From: Martyn White
Sent: 05 April 2019 15:53
To: Planning.Responses
Cc: Amber Willard
Subject: BR/14/19/PL

BR/14/19/PL

The application relates to the retention of a storage container to the front of the existing property. The site adjoins a terraced property which has been identified as Grade II listed.

SITE PLAN - 1/500

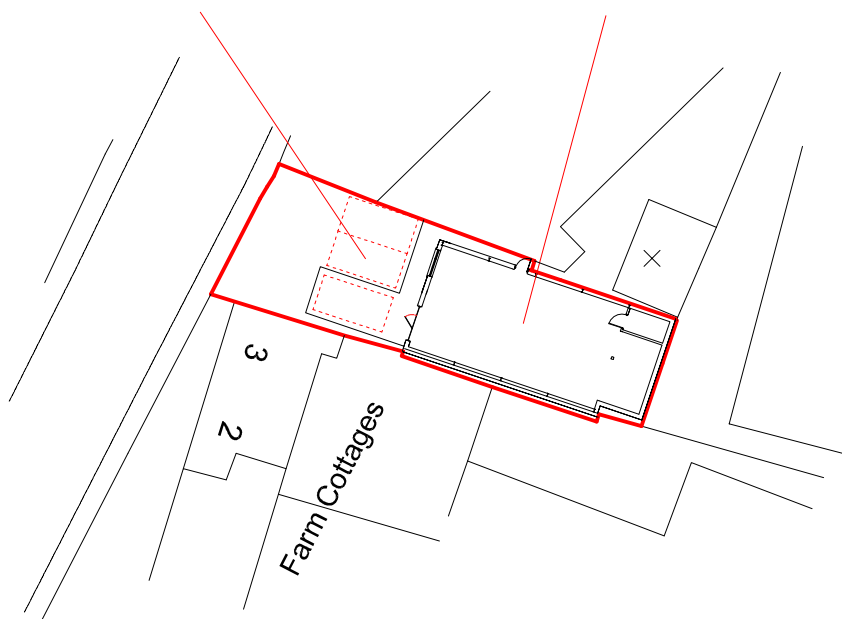
The container is located to the very front of the application site, and is visible from the street. It is read in the context of the listed terrace, and it is considered not to be suitable; development in this context should reflect the character of the listed terrace, and not be in conflict with it. Development is therefore considered to cause a low level of harm the setting of the listed building.
